Table of Amendments to draft Development Consent Order

Part of DCO	Change	Reason
Deadline 2 (18 March 2020)		
Article 2 Interpretation: "Environmental Statement"	Date of submission version of Environmental Statement inserted.	Amended in response to the ExA's question ISH1.
Article 2 Interpretation	The definition of 'works plan' changed to 'works plans' for consistency with article 16.	Amended in response to the ExA's question ISH2.
Article 2(3) Interpretation	The words 'Requirement 14 (Detailed Design Approval) have been inserted before 'of Schedule 2'.	Amended in response to the ExA's question ISH3.
Article 2(4) Interpretation	The words 'Schedule 1 of' have been inserted after 'authorised by'.	Amended in response to the ExA's question ISH4.
Article 4(1) Effect on K3 planning permission	The word 'commence' has been replaced by 'start'.	Amended in response to the ExA's question ISH18 to avoid any confusion between the defined term 'commence' in relation to works, and 'commence' in relation to operational use.

Title **WKN Parameter Plan**

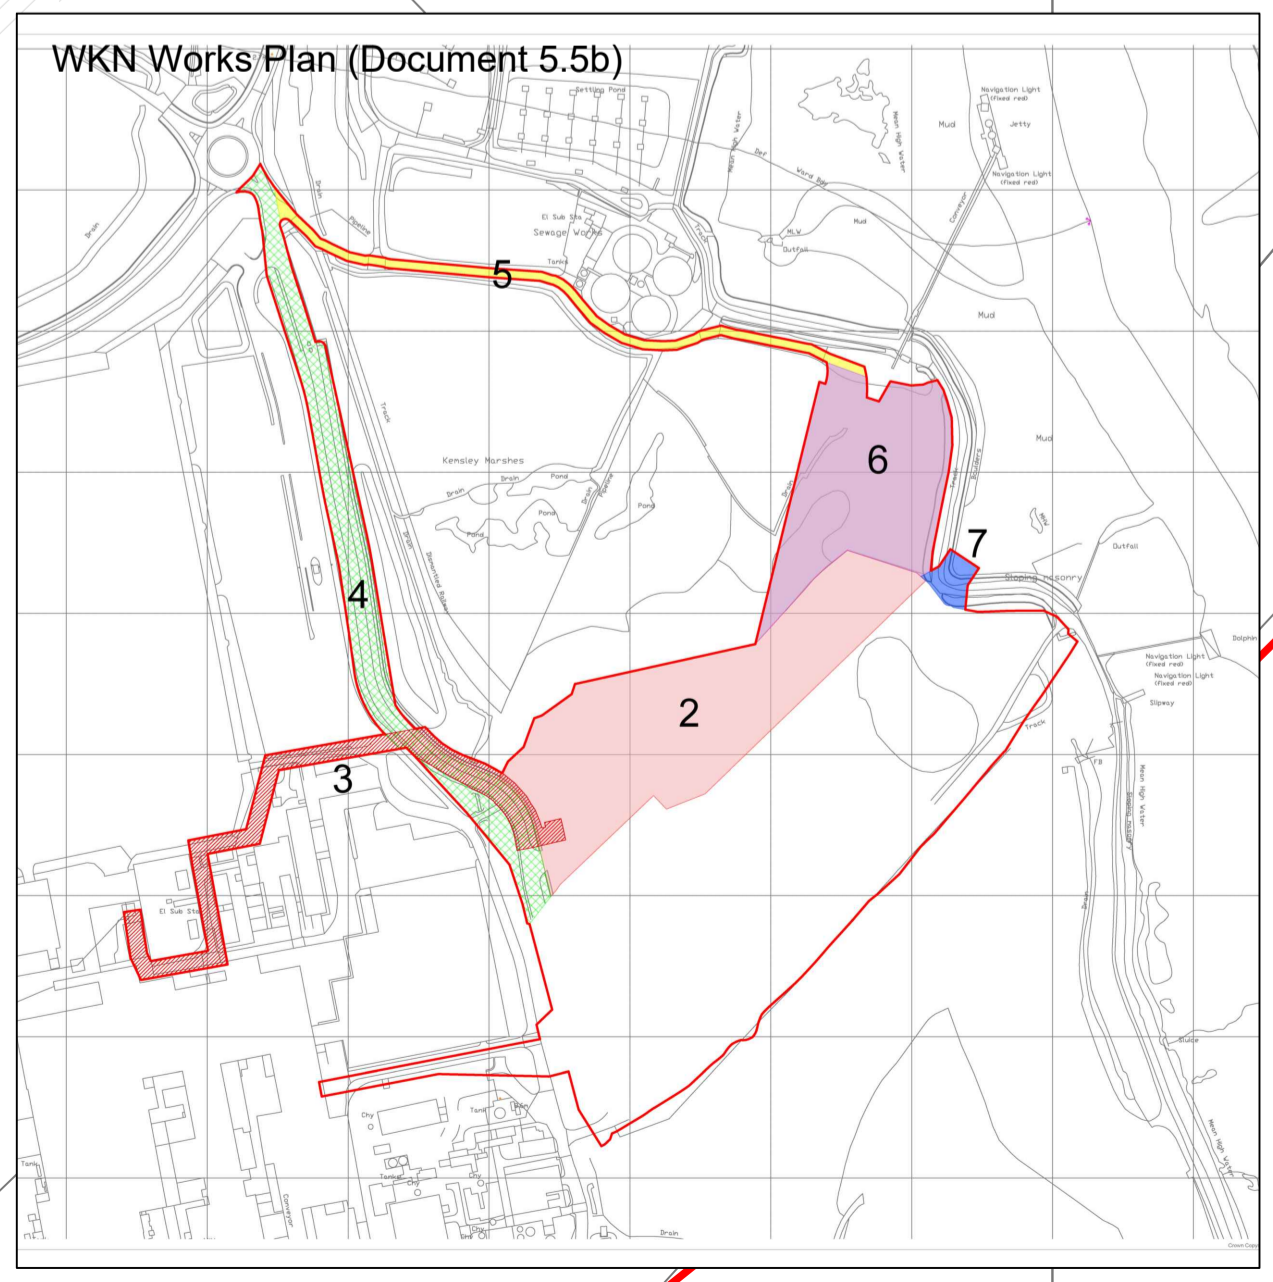
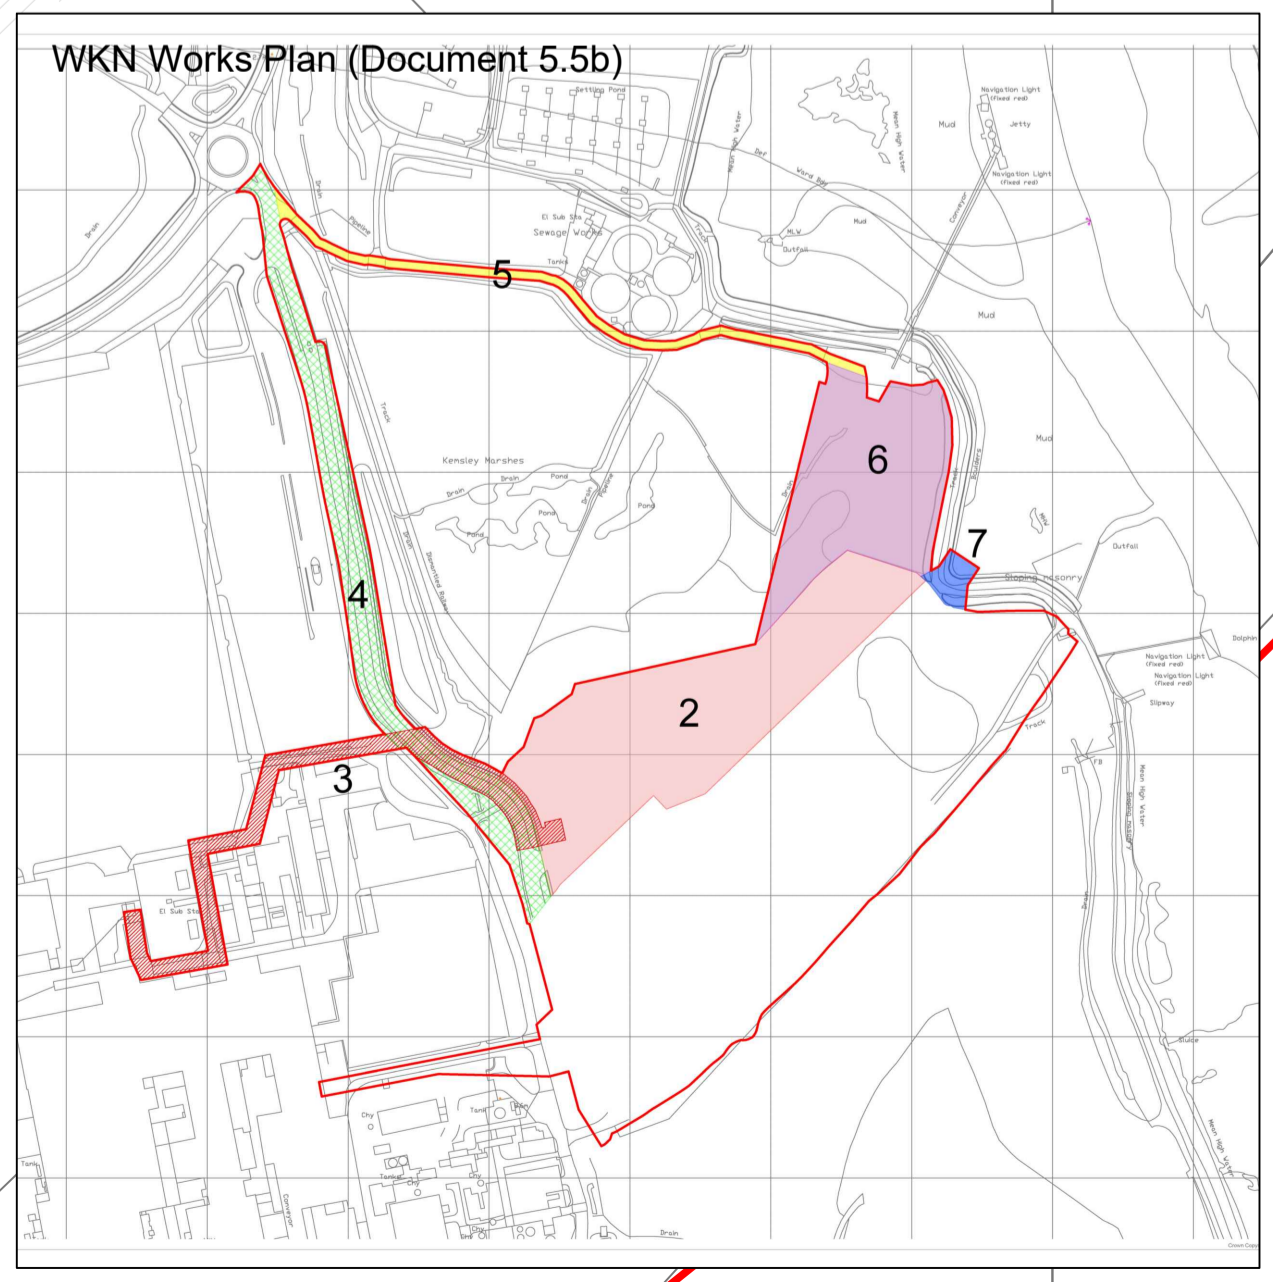
Schedule 2 Requirement 14(4) Detailed Design Approval	Duplication of "(4)" deleted. Definition of "WKN parameter plan" moved to requirement 1.	Amended in response to the ExA's question ISH30.
Schedule 2 Requirement 14 Detailed Design Approval – Table 1	The maximum height of Work No 2(j) Administration Office has been corrected to 30m to be consistent with Table 2.3 of the ES.	Amended in response to the ExA's first written questions 1.2.4.
Schedule 2 Requirement 16(4) Implementation and maintenance of landscaping	Reference to the 'annual landscaping maintenance plan' has been corrected to the 'approved landscaping scheme'.	Amended in response to the ExA's question ISH31.
